**CITY OF MERCER ISLAND**

DEV17-001 review

February 23, 2017

RE: DEV17-001 Fence Height Deviation, 6753 WMW

FENCING PLAN

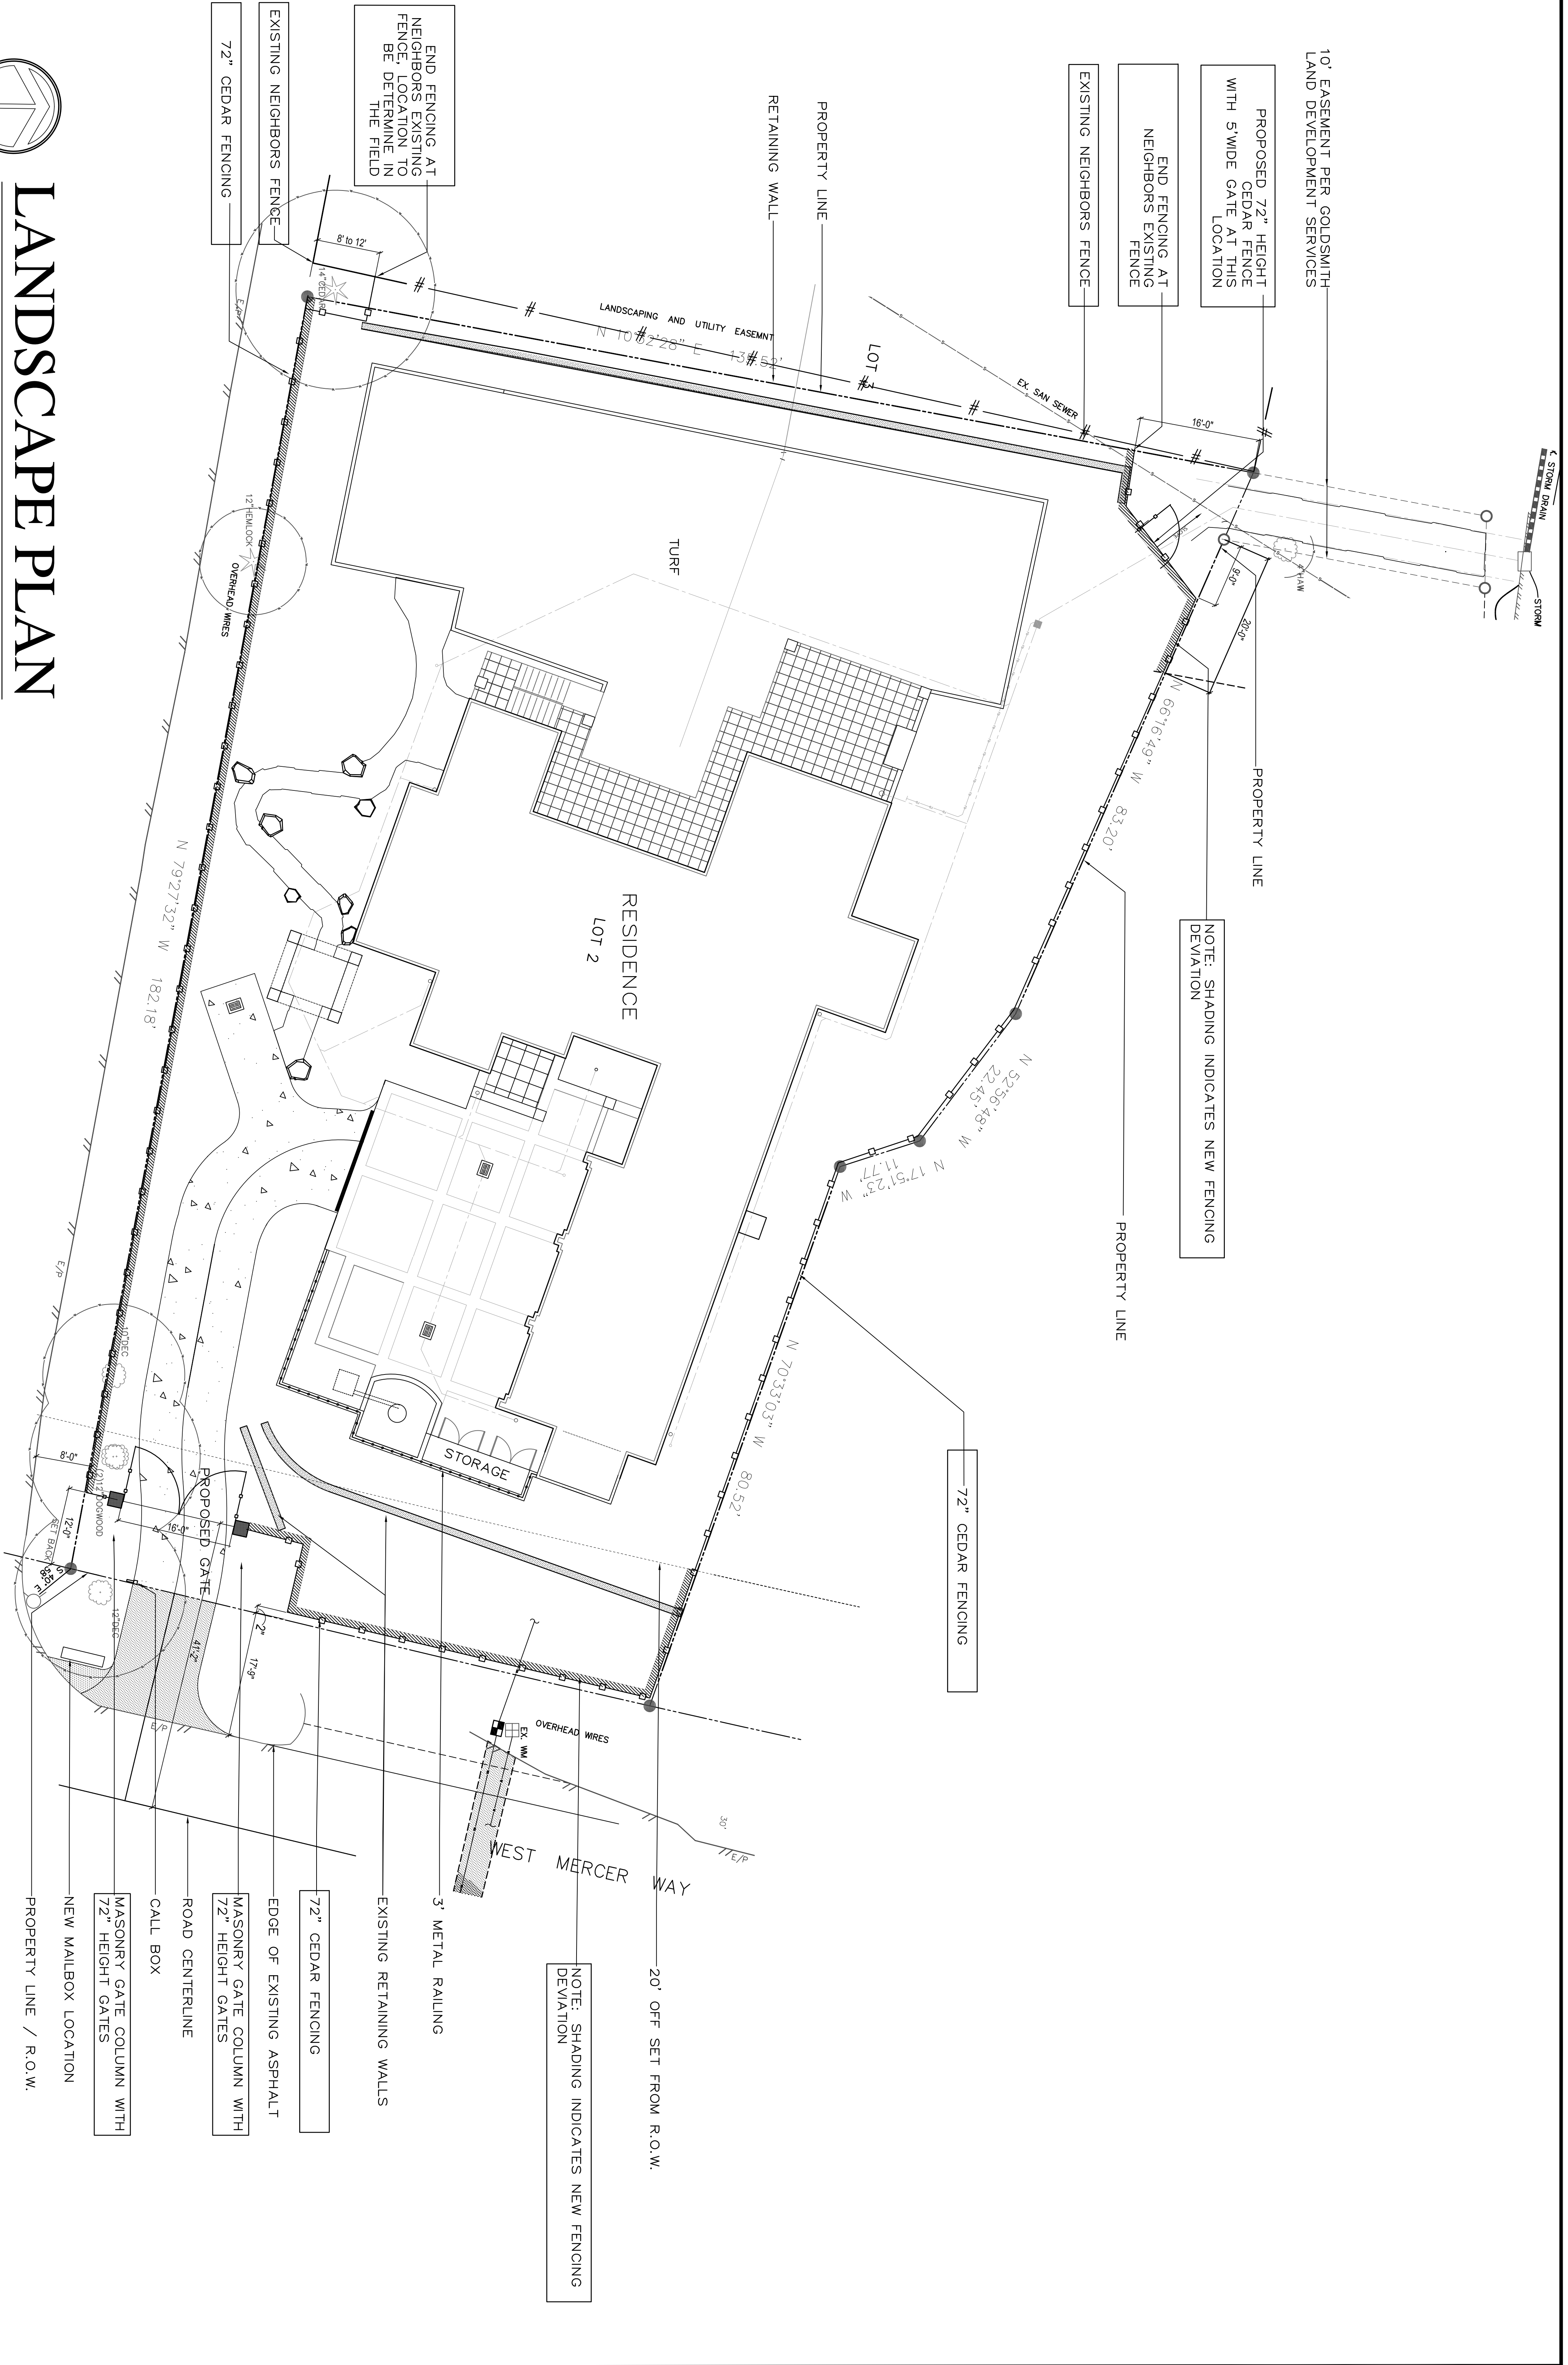
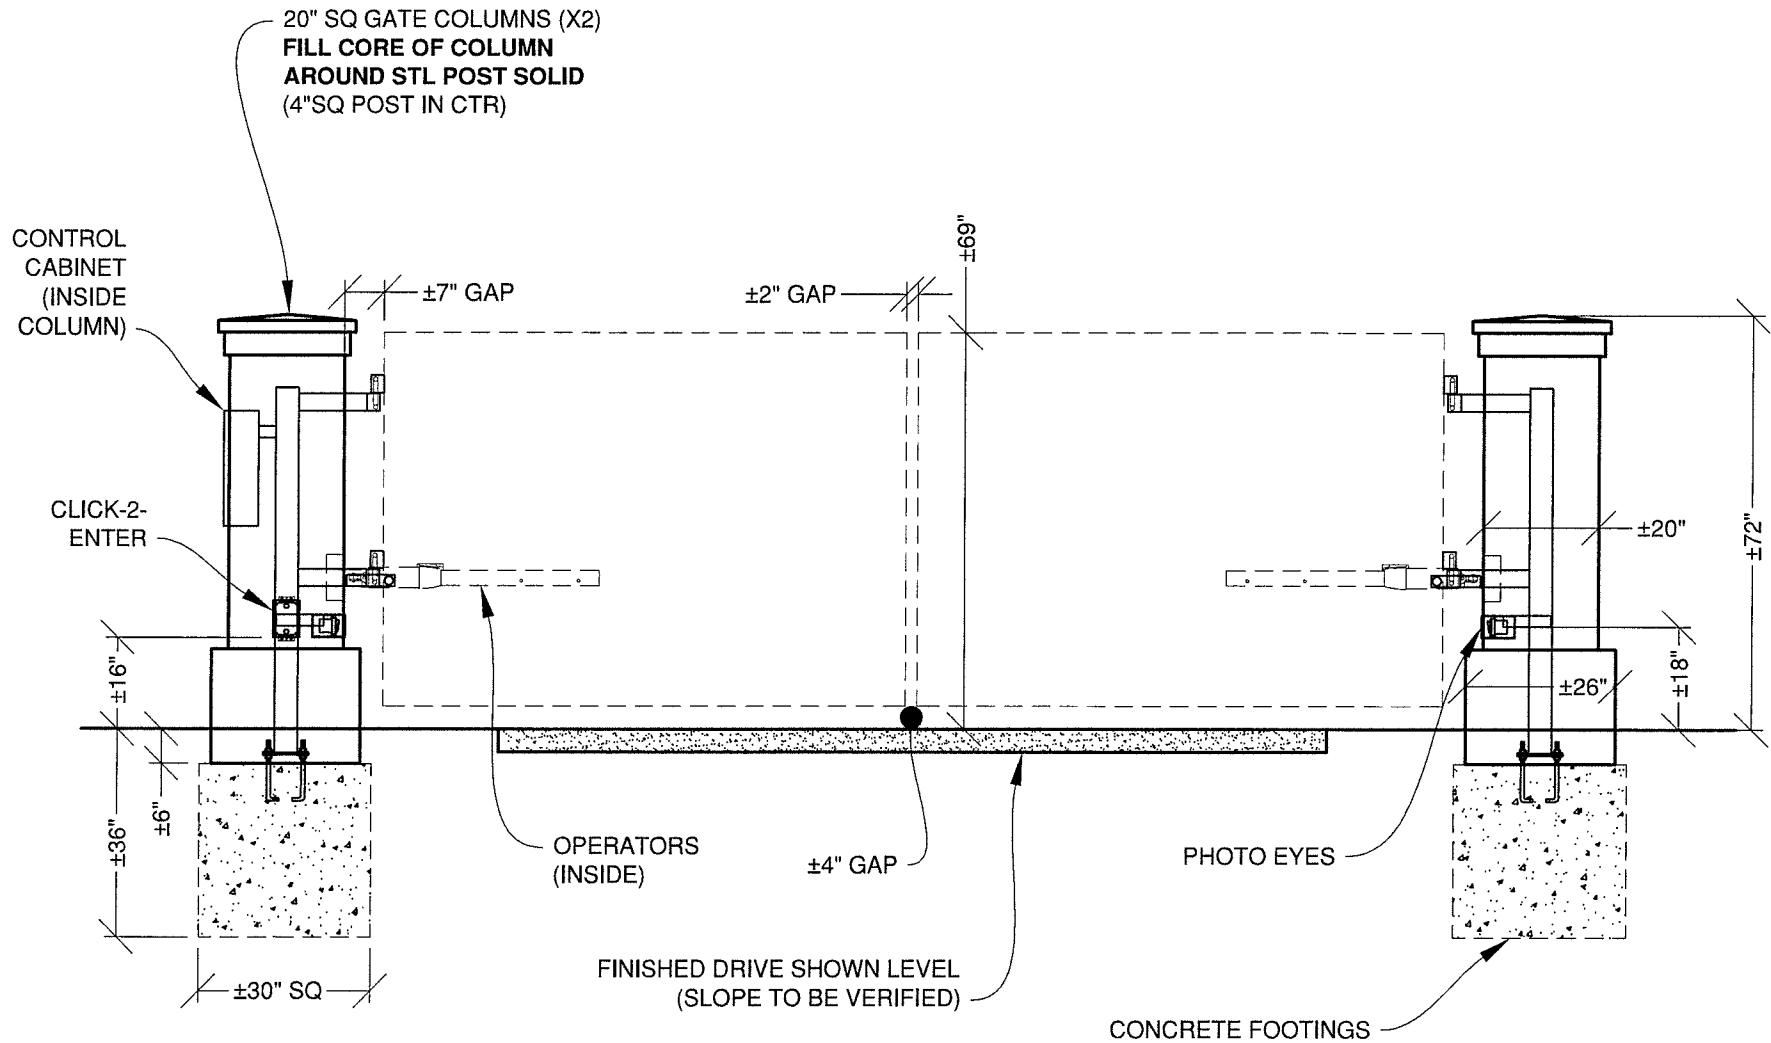
2. Please update the deviation request to include parts of the property line that are within 20 feet of an improved street. Due to the south side of the property line abutting a shared access drive, which is considered a street, the deviation request needs to include the proposed 6 foot cedar fence along the South end property line. Deviations are needed for gates and fences above 42 inches within 20 feet of an improved street. This also includes the entire East property line that abuts West Mercer Way. According to MICC 19.16 "street" is defined as "an improved or unimproved public or private right-of-way or easement which affords or could be capable of affording vehicular access to property."

4. Please provide an additional site plan without the contour lines and vegetation, and indicate the distance from the gate and fence to West Mercer Way, as well as the driveway abutting the South end of the property.

**GATE PLAN**

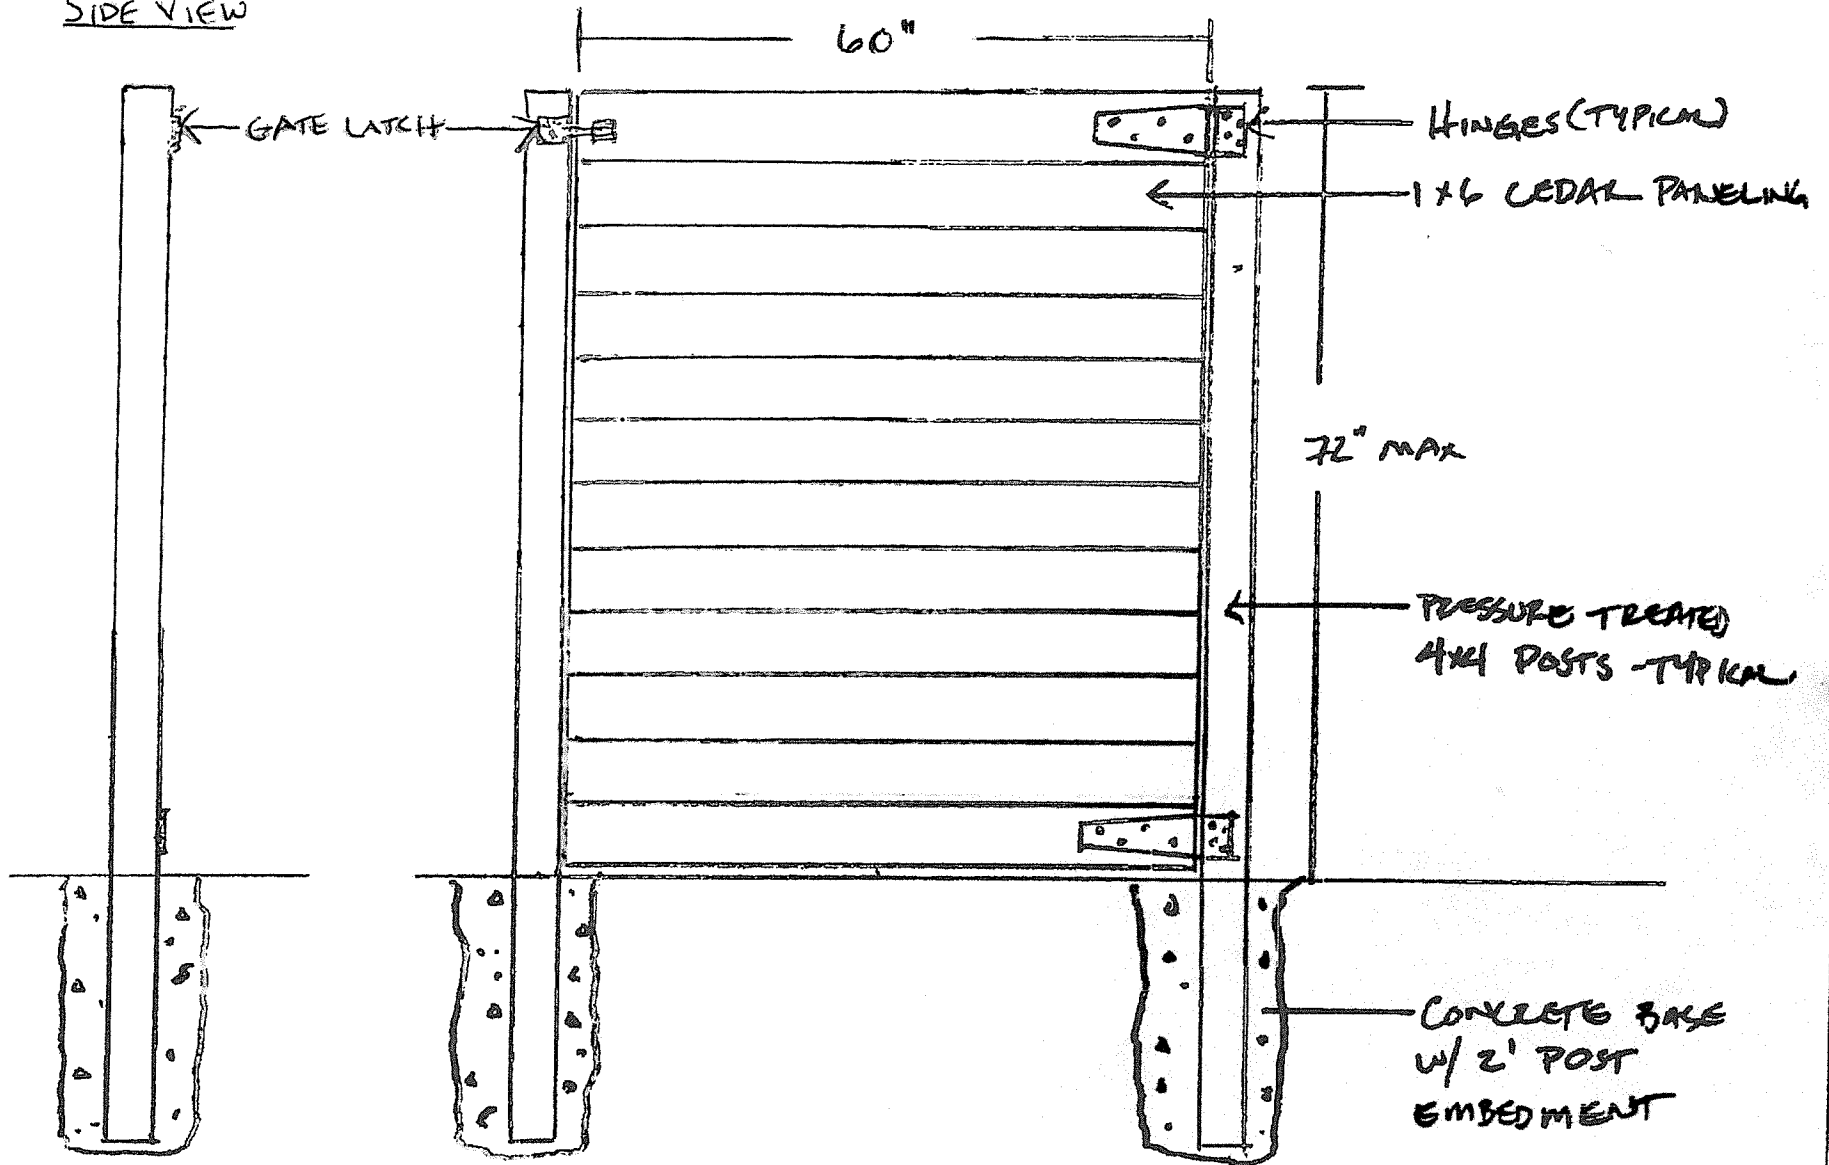
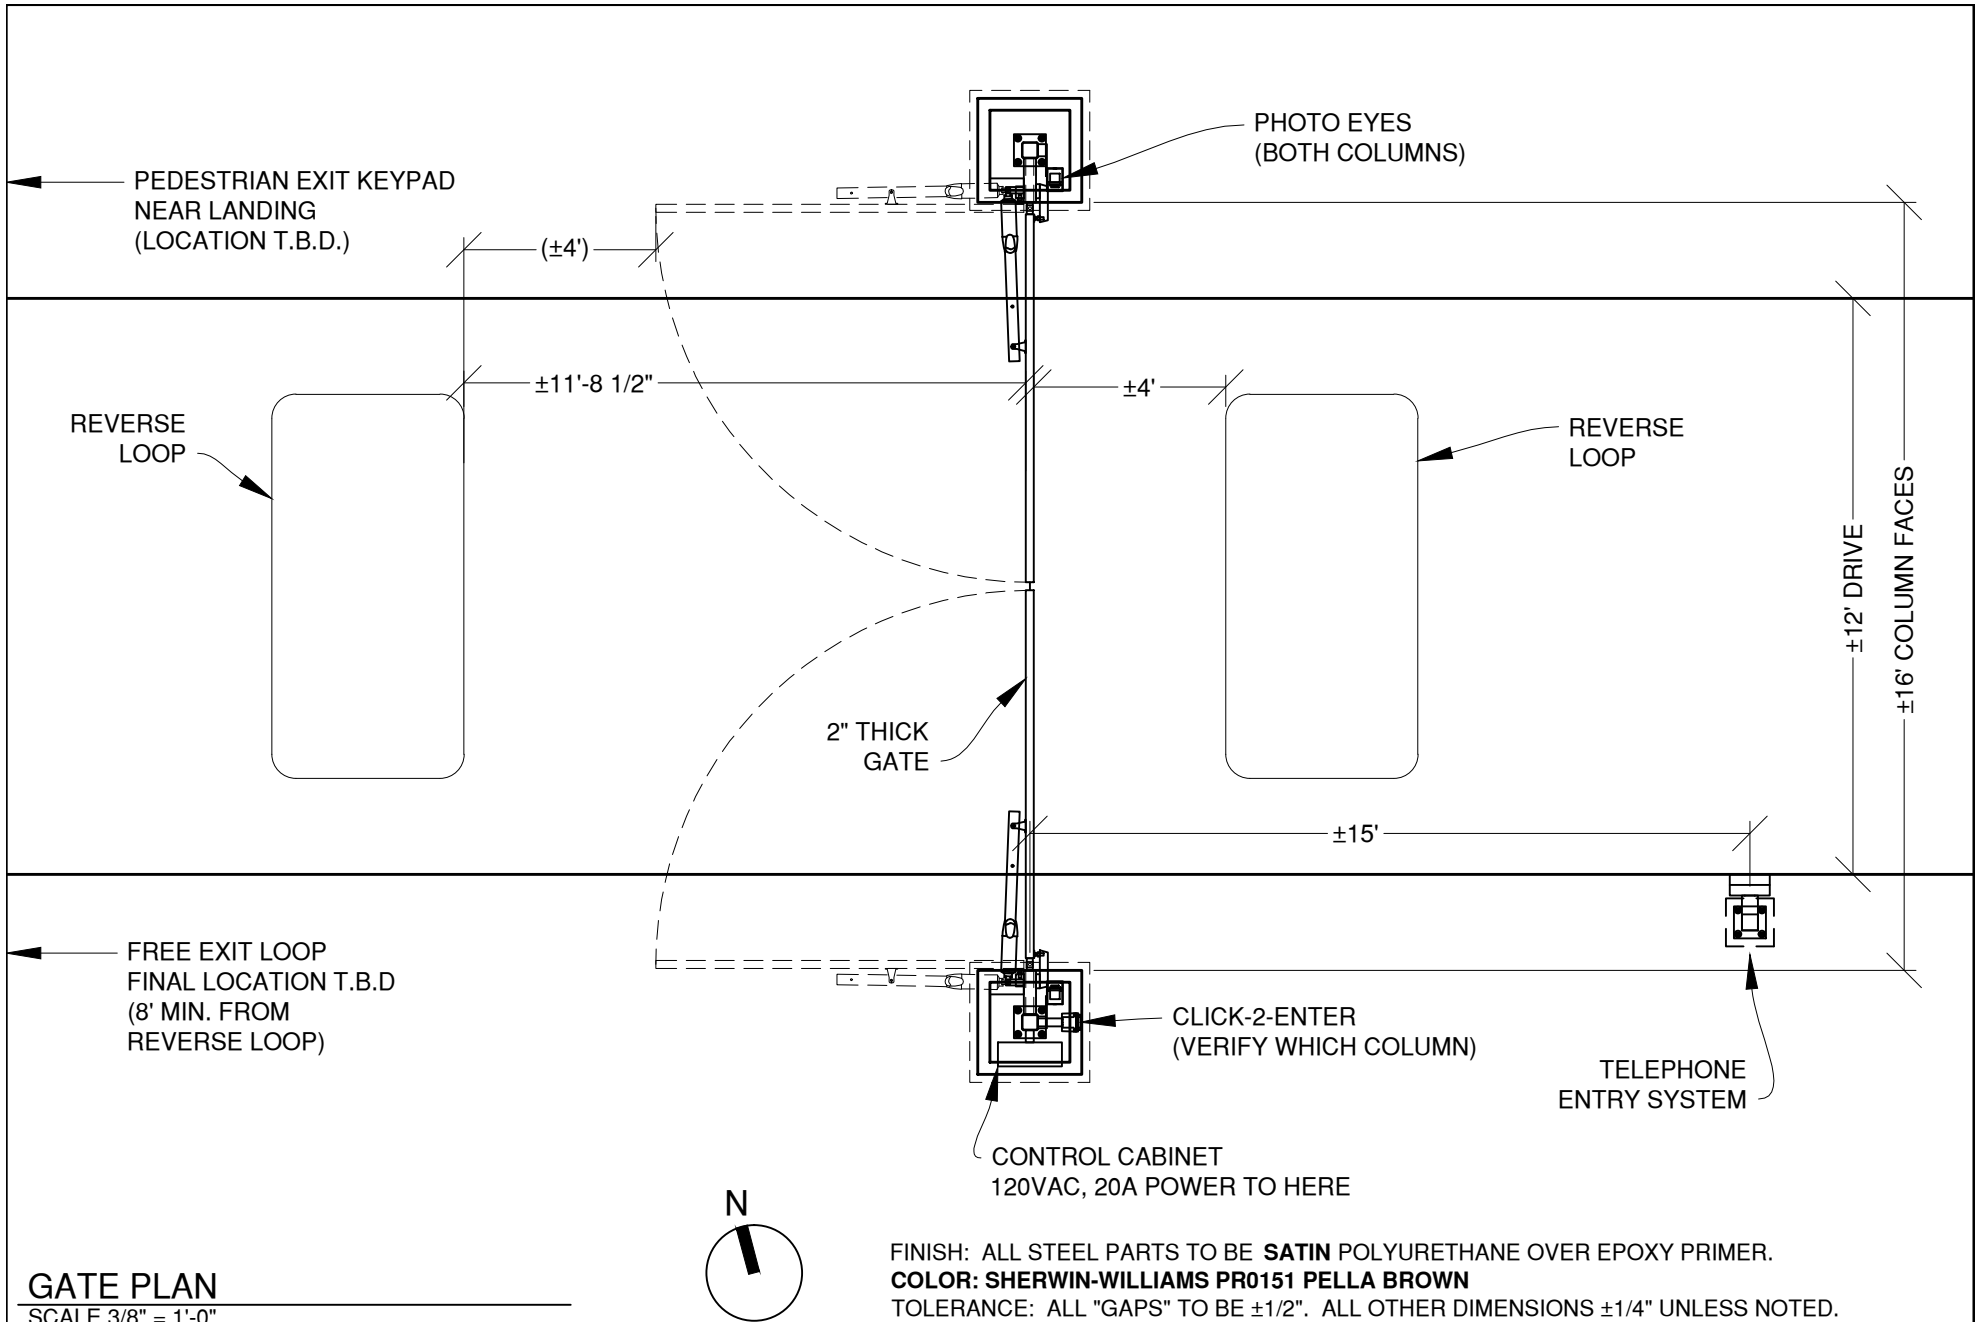
1. Please revise the plans to reflect a maximum fence height of 72 inches. The fence height deviation allows for a maximum 72 inch high fence and gate, and the gate is currently 75 inches high including the side posts. The side posts need to be reduced in height in order to comply with the 72 inch maximum height. An alternative would be to reduce the height of the gate side posts and reduce the height of the gate, if modulation is preferred visually.
